Application No: AW/31/21/HH
Site Address: 3 Haydon Close Aldwick PO21 4LG
Description of works: Single storey rear extension and front porch

Thank you for your internet representation made on 27th February 2021 which has been recorded as an objection with the comments as follows:

OWPC34121

Mr. & Mrs. Vitanyi
3 Haydon Close, Bognor Regis
West Sussex PO21 4LG
PROPOSED ELEVATIONS
Date: JAN 2021 Scale 1:100 Dw no. PR.EL 06

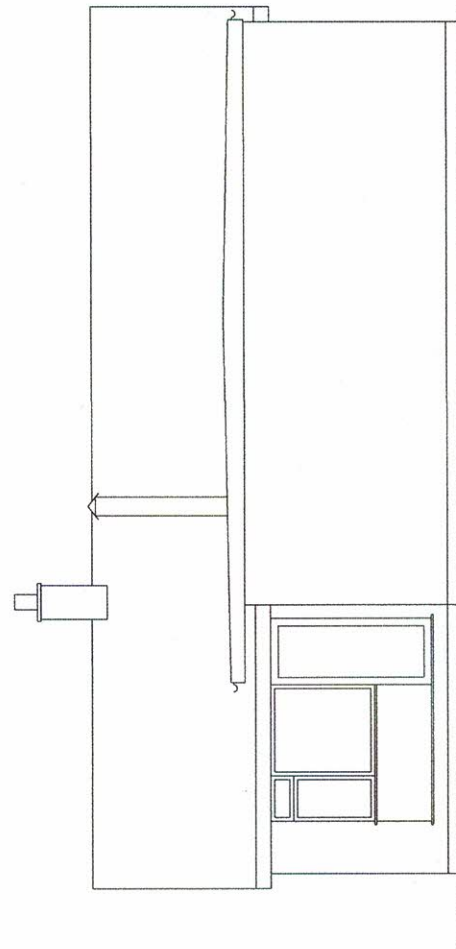
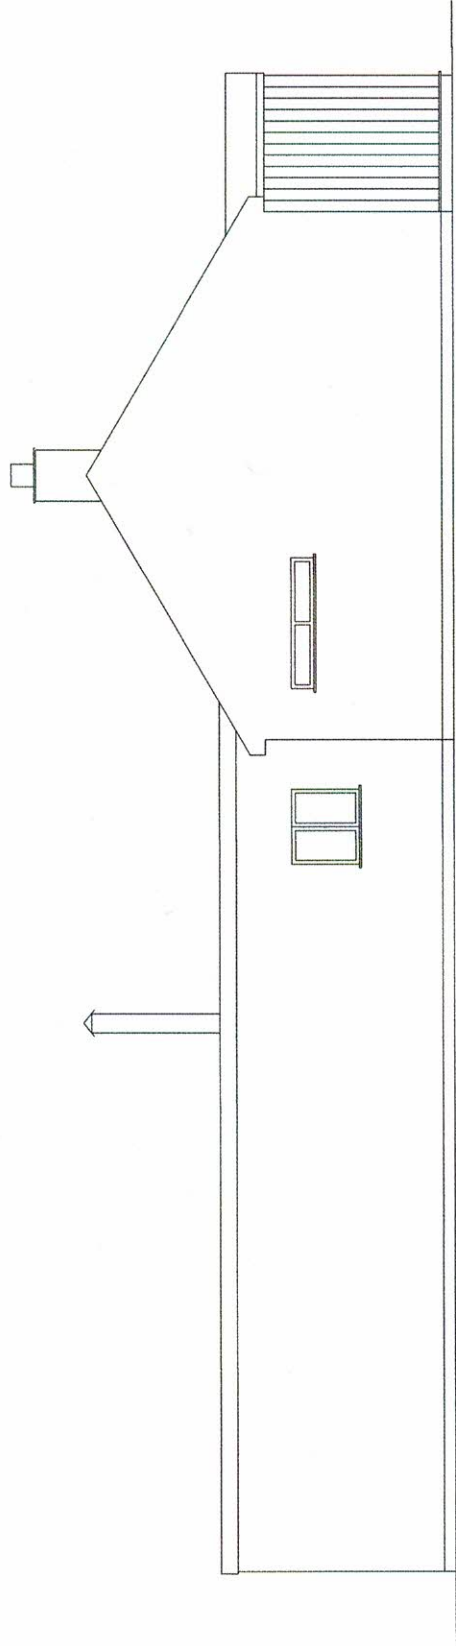
The design appearance (Flat roof) and materials proposed are not in keeping with the original structure or other habitable properties in the area.

The exposed chimney, with an extended height, is not in keeping with the original building, the appearance more for an industrial appearance rather than a residential setting.

Right to light, loss of light, and overshadowing of adjacent gardens by the extension, the proposed extension is twice the height of the current boundary fences.

Date: JAN 2021 Scale 1:50 Dw no. PR.FP. 06

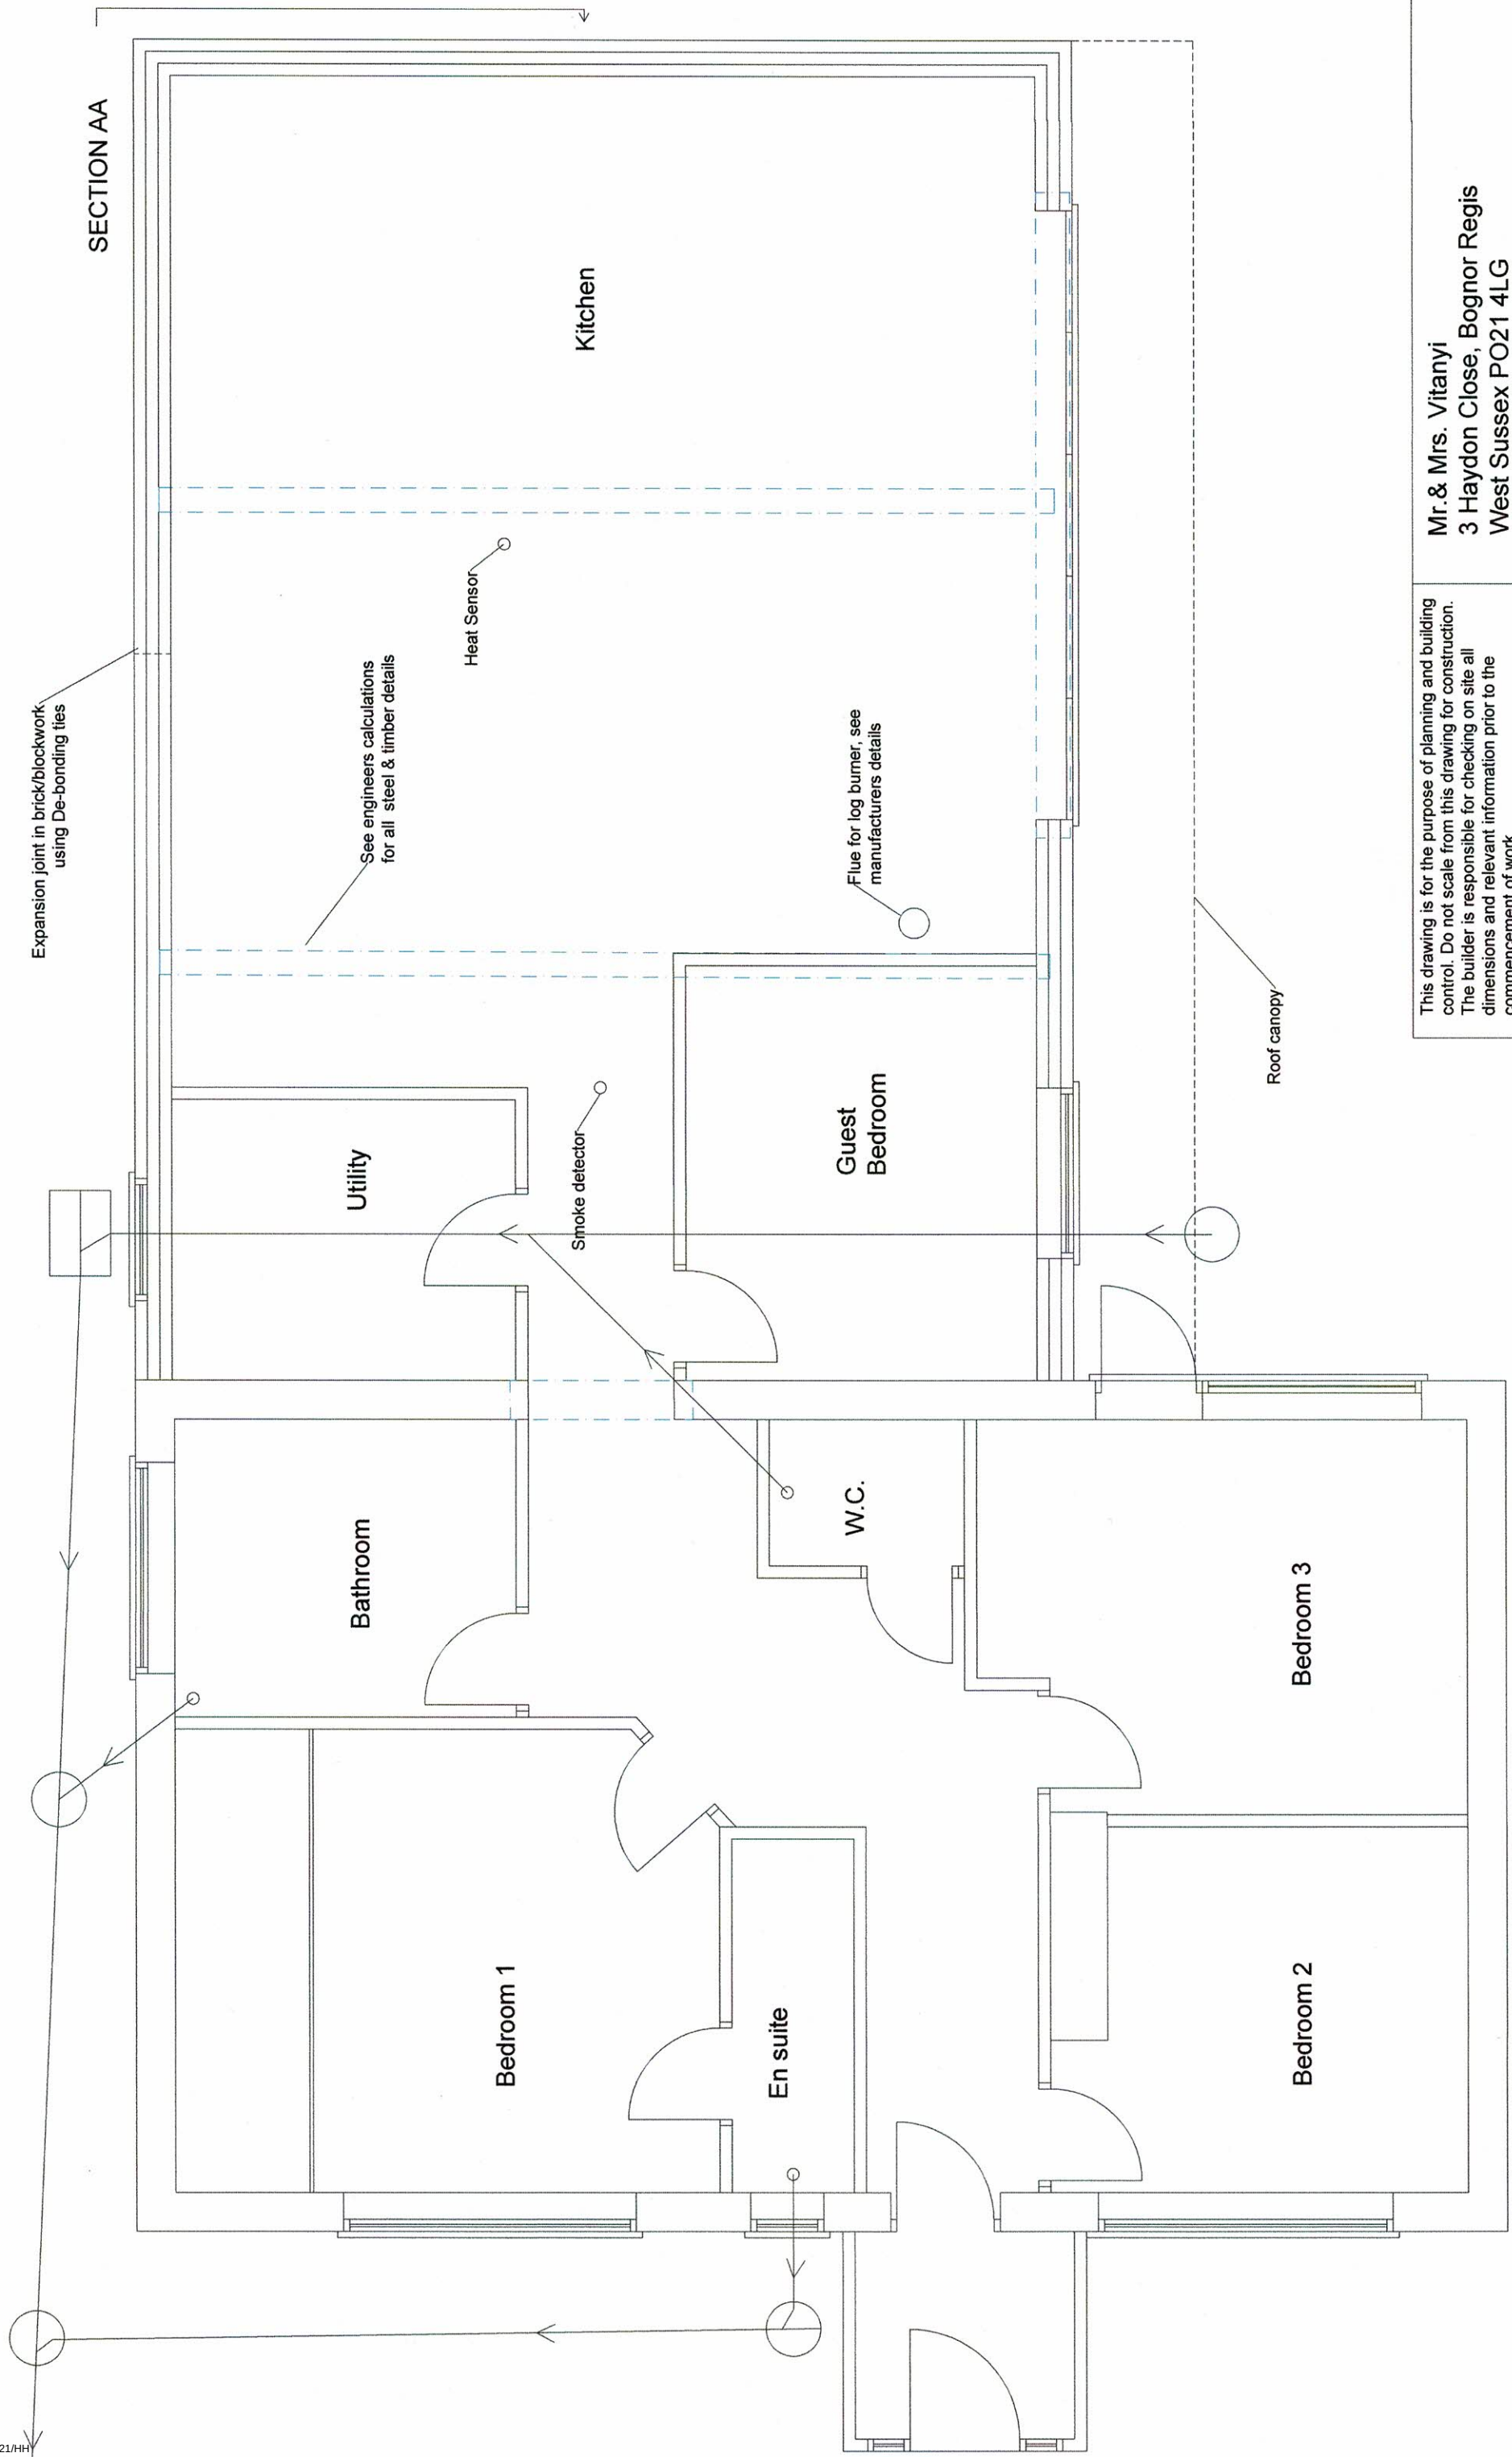
The extension is not in keeping with the original building, more than doubling the floor area of the original property.

The proposed extension mainly a kitchen will have a negative impact on the amenity of the adjacent properties, through noise, overlooking, overshadowing, smells (kitchen), loss of daylight, and loss of privacy. Approval of this extension would create a precedent meaning that it would be difficult to object to similar property extensions, not in keeping with the original building.
